Appeal Decision

Decision date: 21 July 2025

Appeal Ref: APP/T2350/W/25/3361823

Pewter House Farm, Commons Lane, Balderstone, Lancashire BB2 7LN

CLIENT DETAILS CARR LANE BALDERSTONES RIBBLE VALLEY	DRAWING No RBV-PL-002		REVISION A
	SCALE 1:100	DATE 05/09/22	DRAWN BY JH

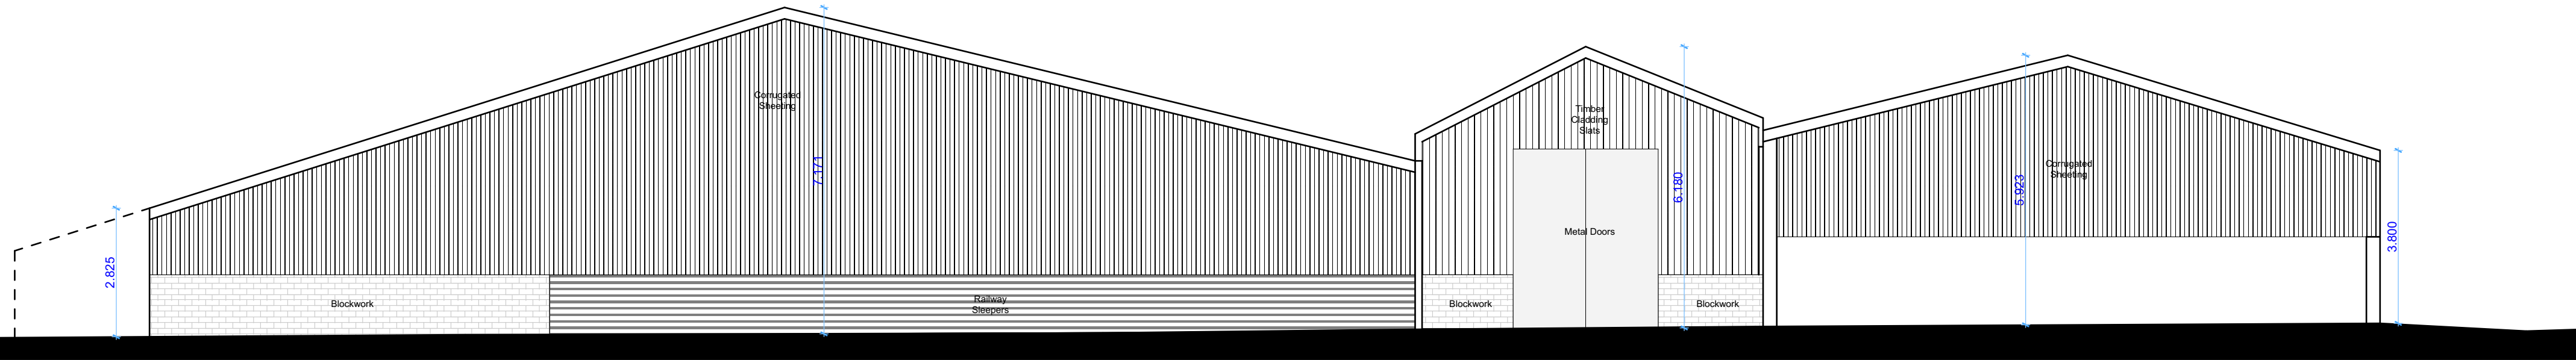
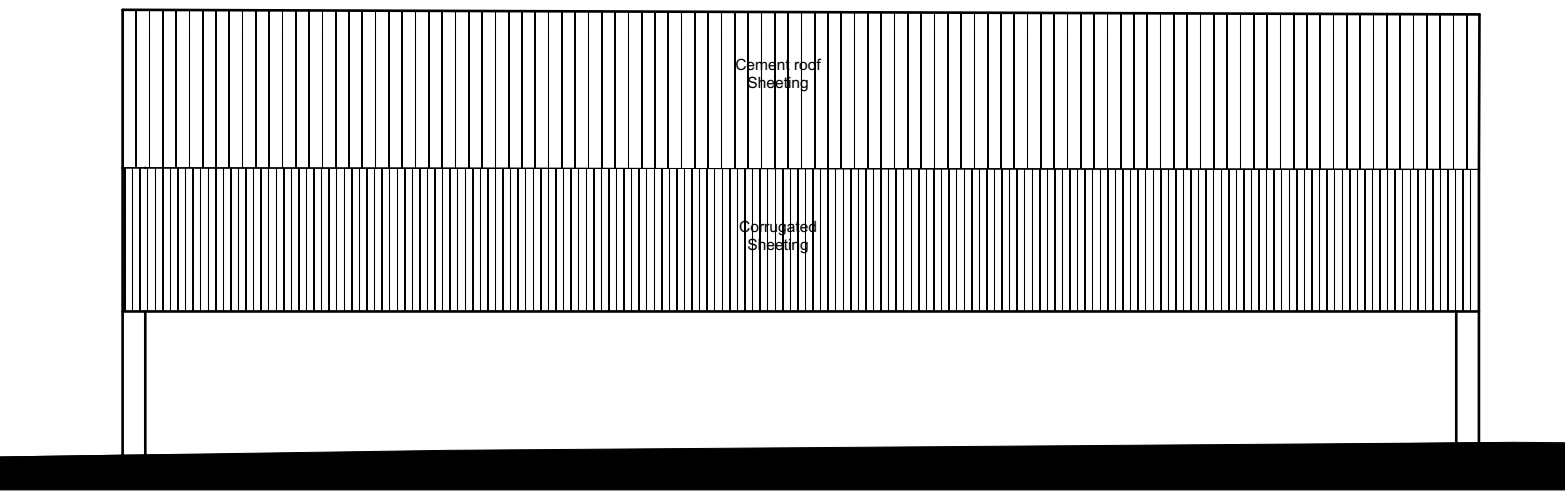
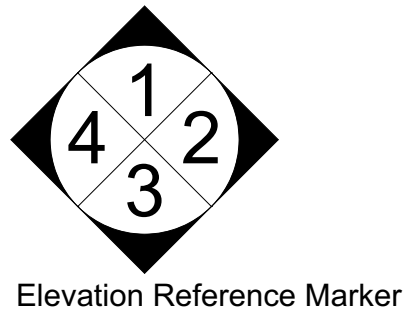
9. The report also stops short of stating that the walling, cladding and roofing materials would be retained. Instead, it refers to an expectation of retention and notes that there is 'no reason why,' the majority of external elements could not be retained. In addition, the elevation drawings are annotated in a manner to allow for cladding repairs and new cladding but falls short of specific detail. This provides no certainty of retention of cladding or roofing material, regardless of their structural integrity. This is particularly pertinent as it was clear from my own observations on site that the cladding and walling shows signs of wear, with some isolated areas broken, and it is of a dated appearance.

10. Significant new building work would also be required to close up the large frontage openings, and the extensive open elements of the northeastern building. This is regardless of the fact that these new build elements are designed to be set back from the front and rear elevations.
